26 January 2016
Our Ref: 14160

Re: Fifteenth Avenue

RMS Comments

Ross Nettle
Director
Transport and Traffic Planning Associates

DRAWING TITLE **TURNING PATHS PLAN**

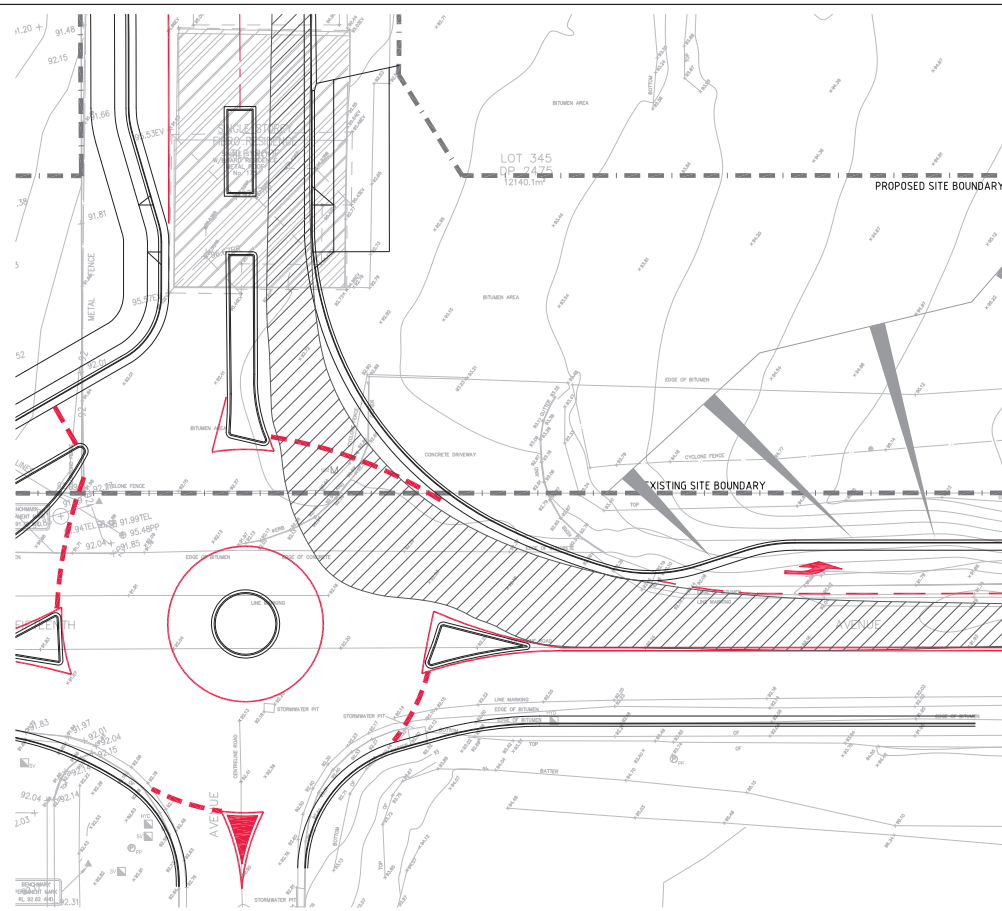
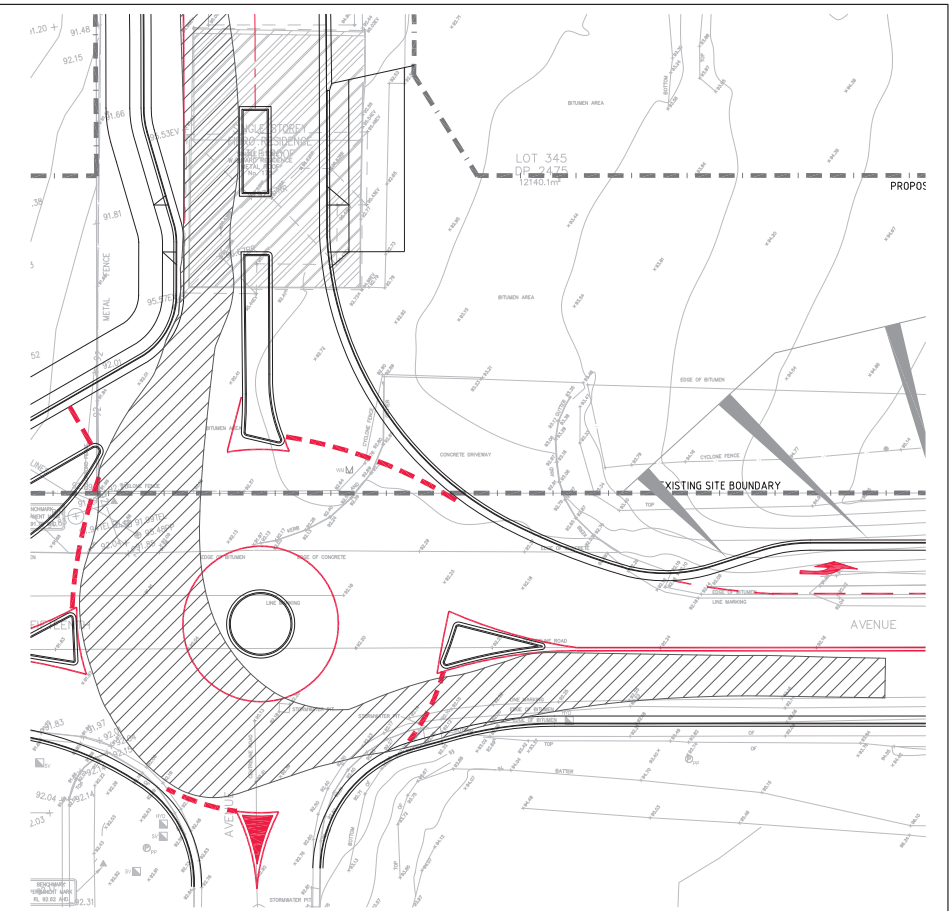
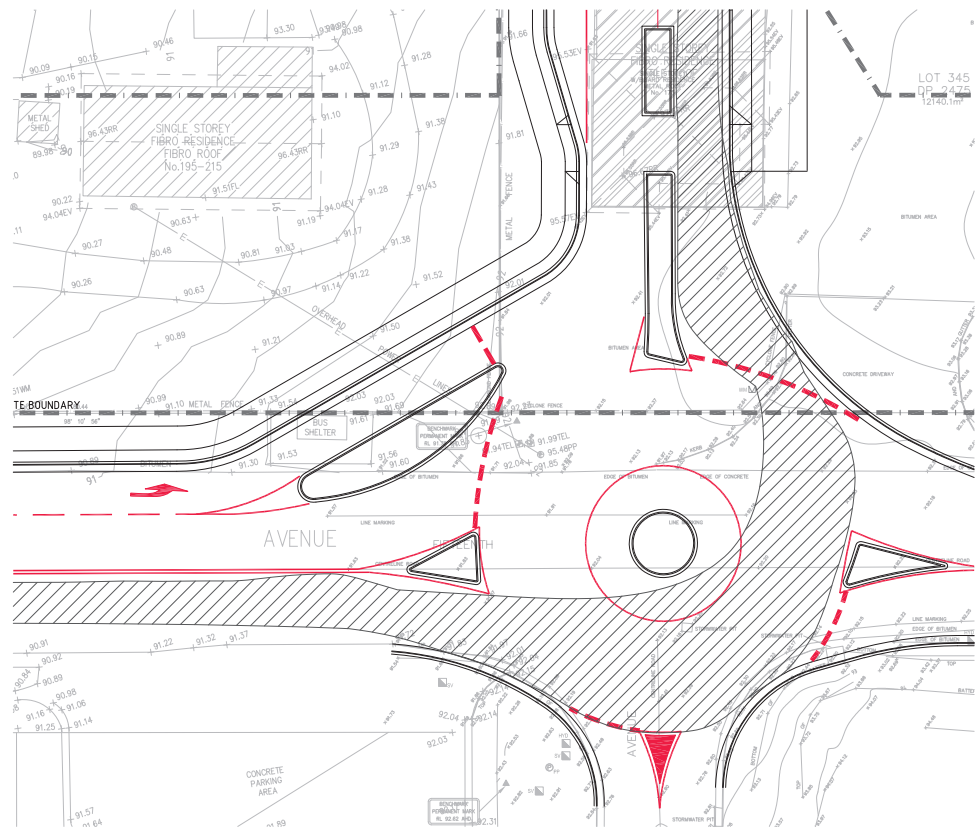
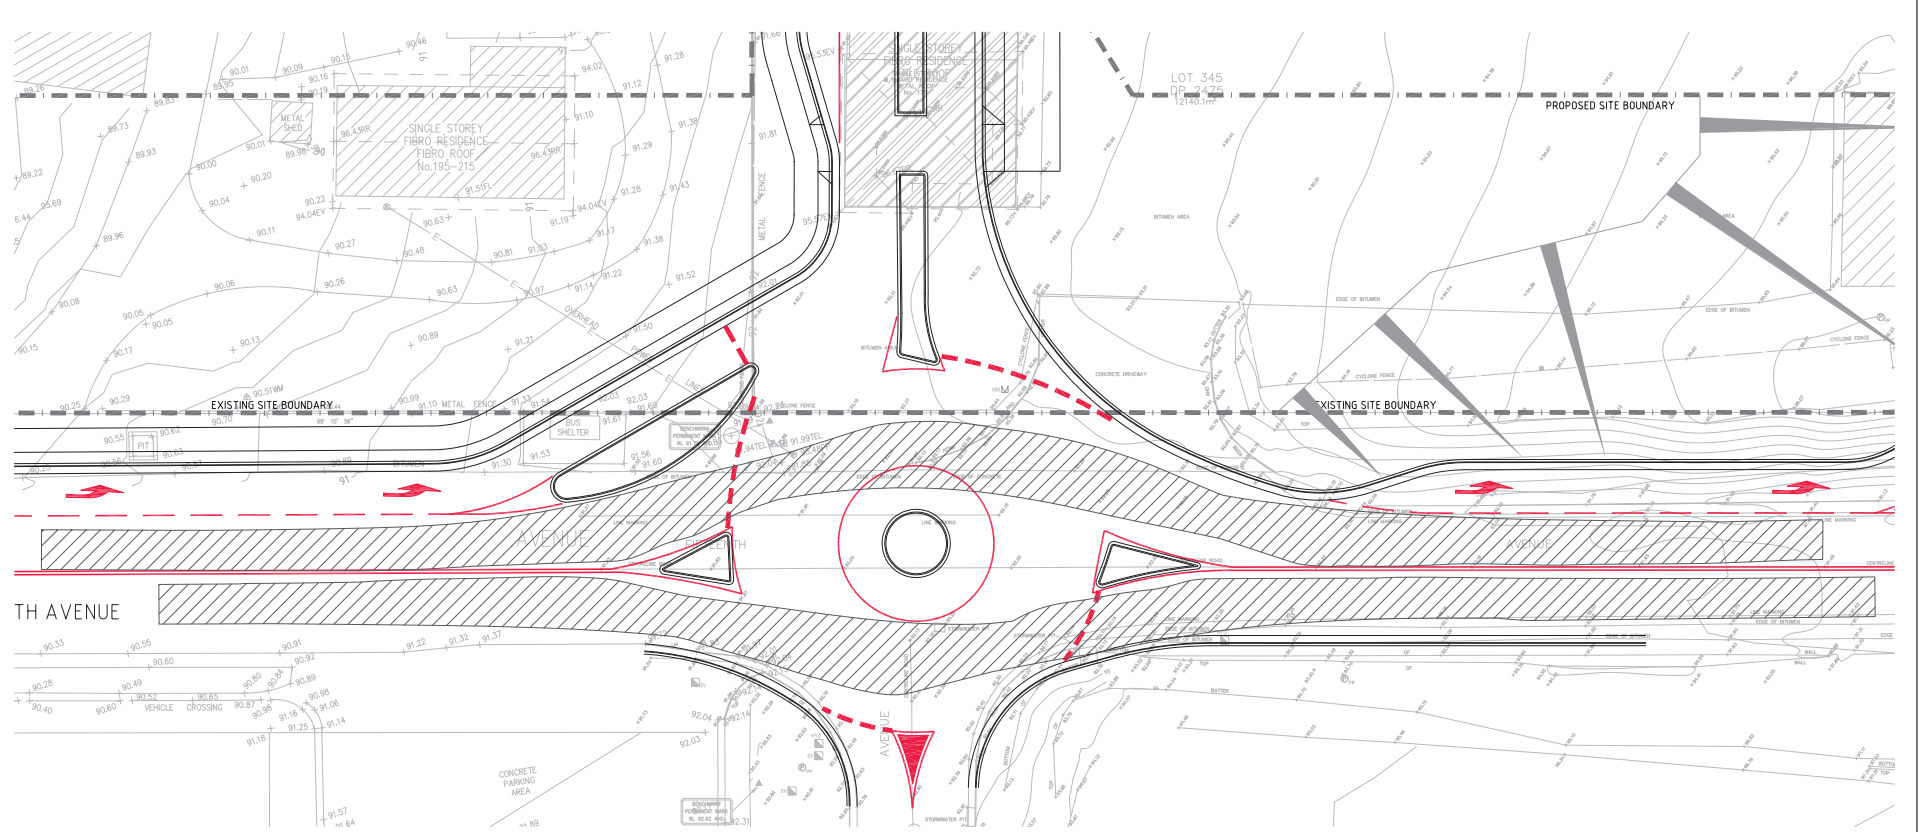
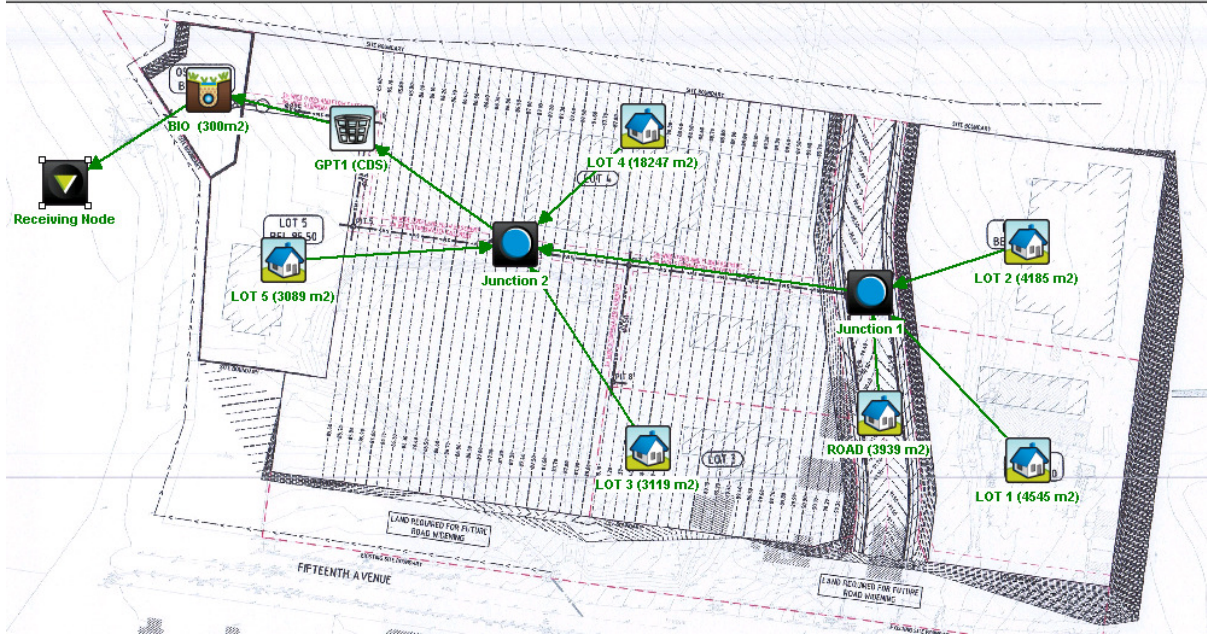
- Proposed Roundabout

- Roundabout Design

The roundabout is designed to accommodate semi-trailers and can certainly accommodate 14.5m buses.

The design will accommodate semi-trailer and bus movements.
